# CITY OF ALBUQUERQUE

August 14, 2017

RE: **Lot 4 Block 6 Unit 18, S.A.D. 228**  
**Volcano Cliffs Subdivision**  
**6616 Kimmick Dr. NW**  
**Grading and Drainage Plan**  
**Engineers Stamp Date; 7-27-17 (D10D00M4)**  
**Pad Certification Date; None**

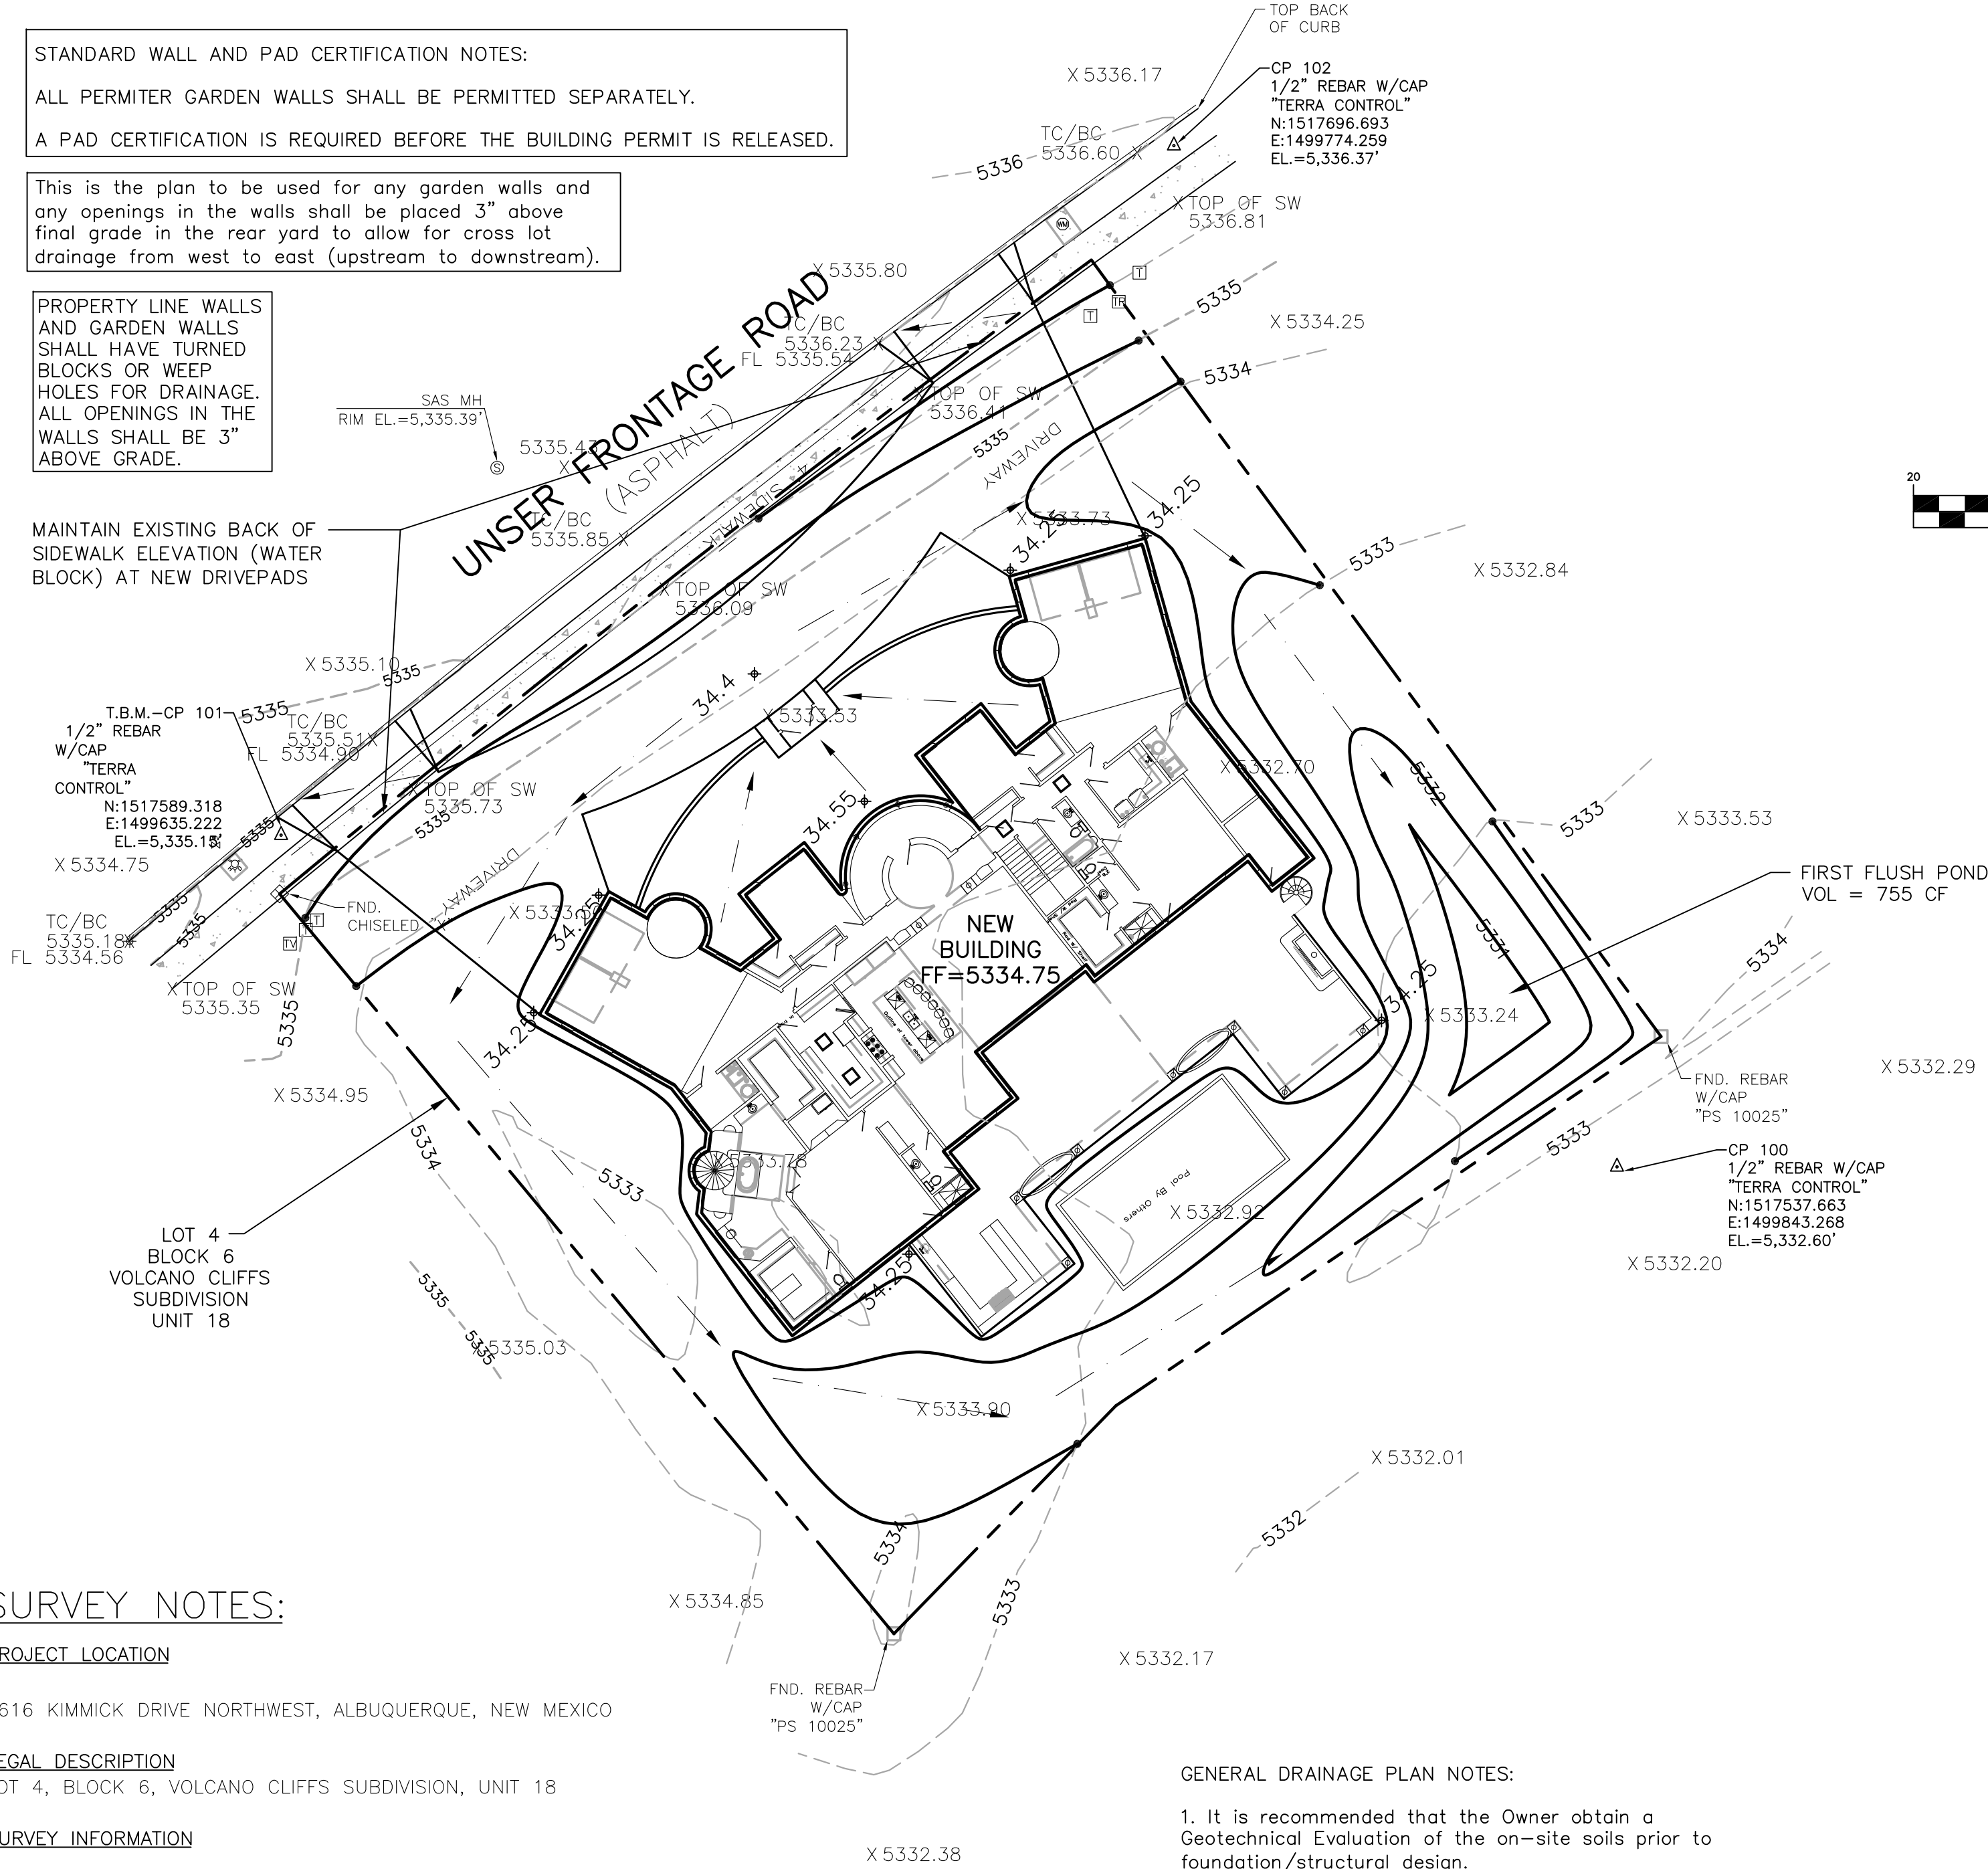
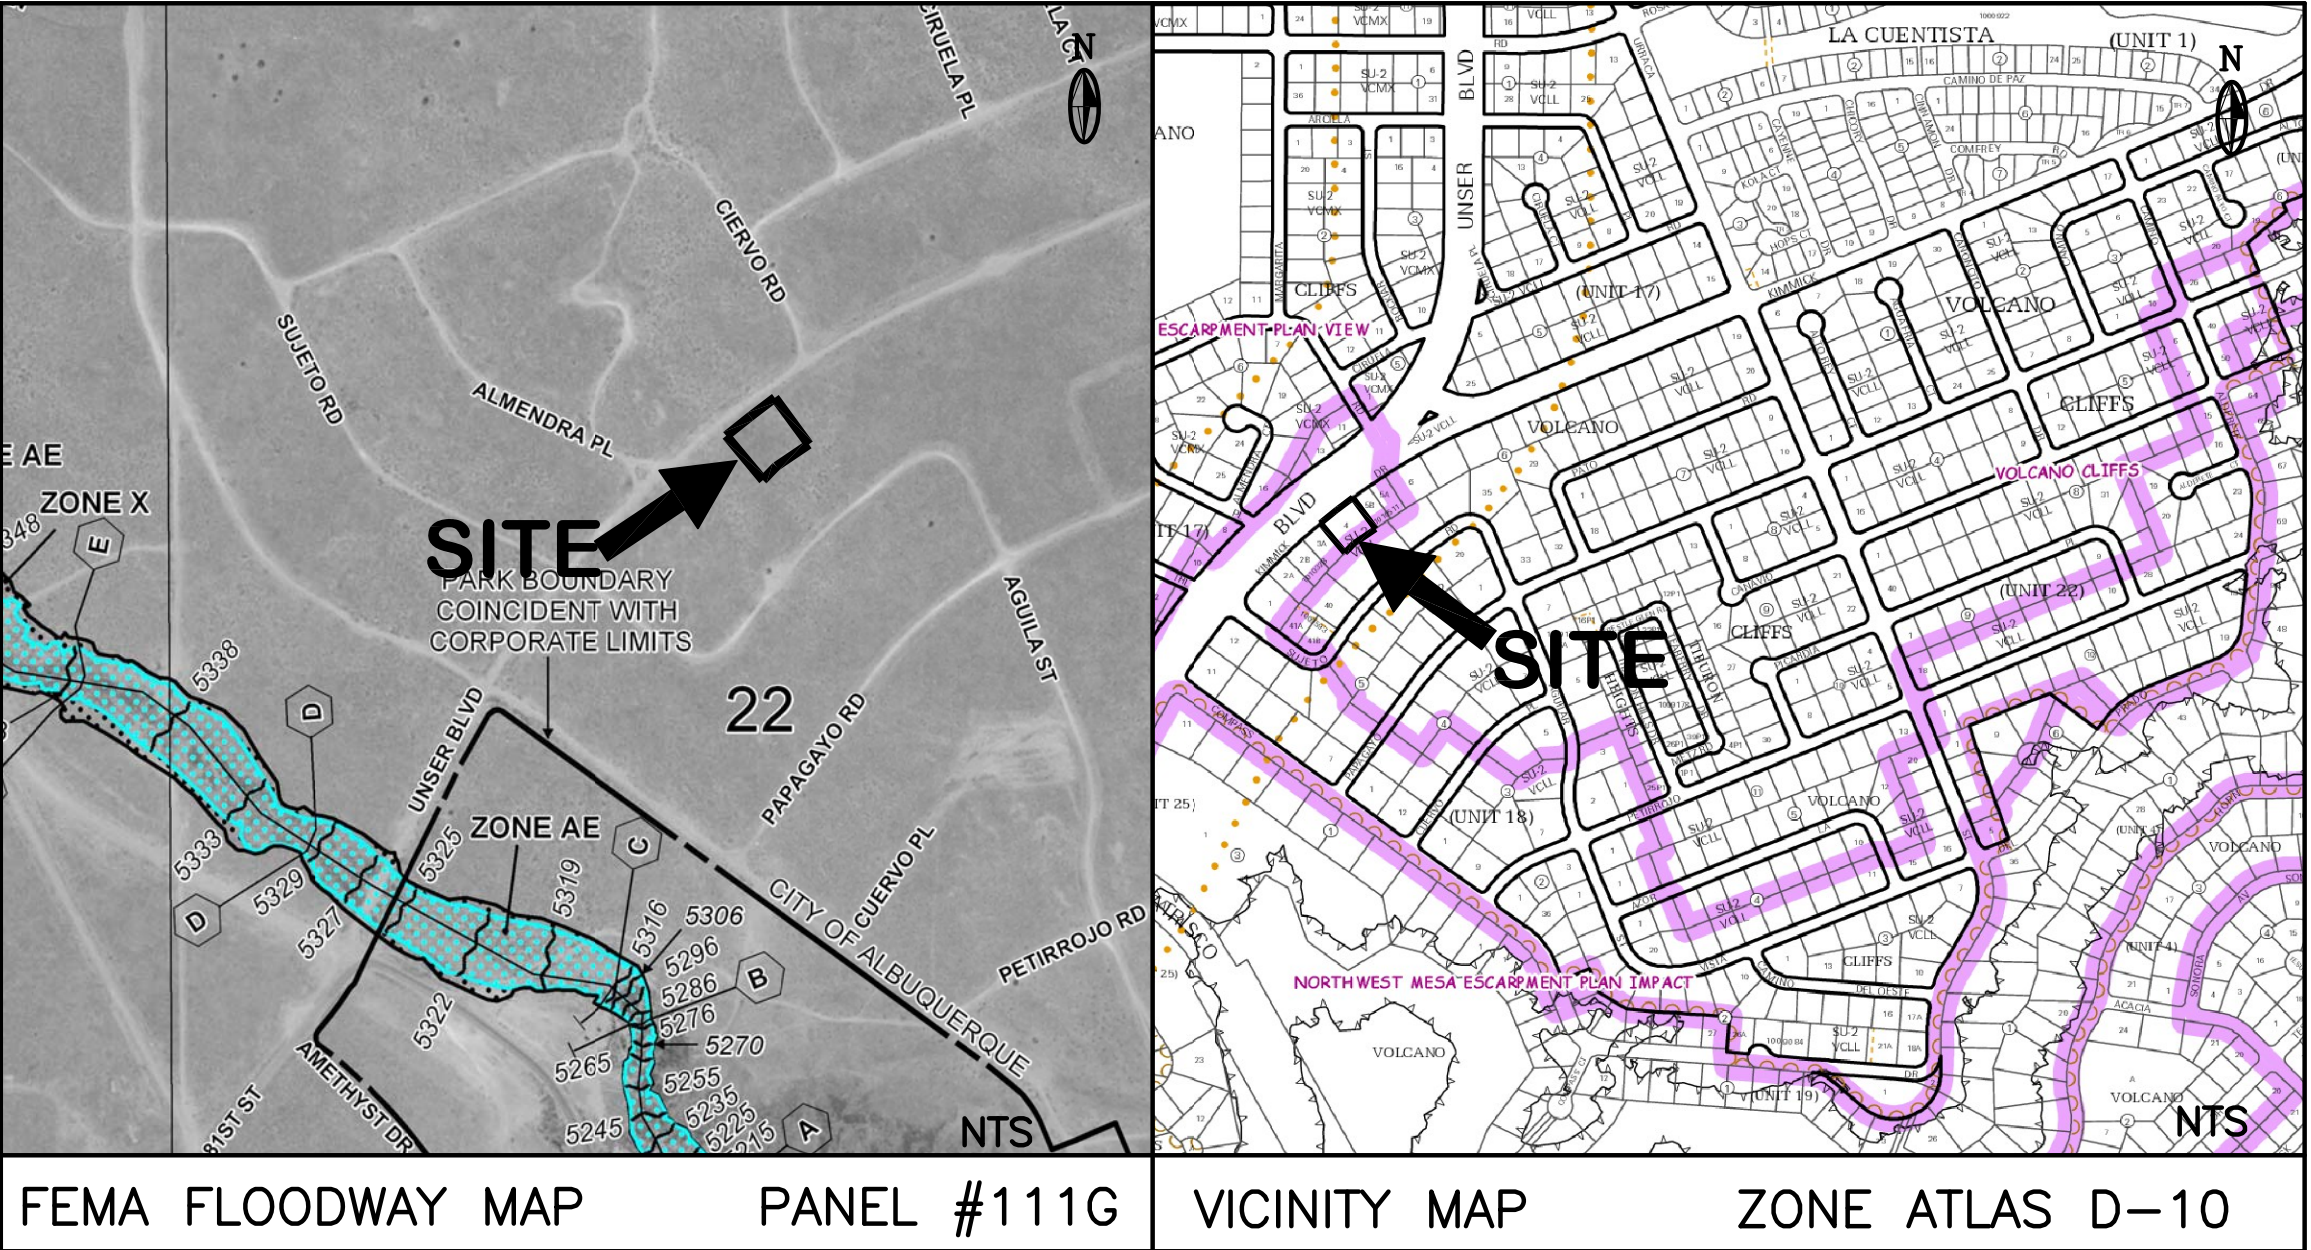
- Provide the Pad Certification language, signed and dated.
- The area is not ready for inspection, compaction roller at this location.
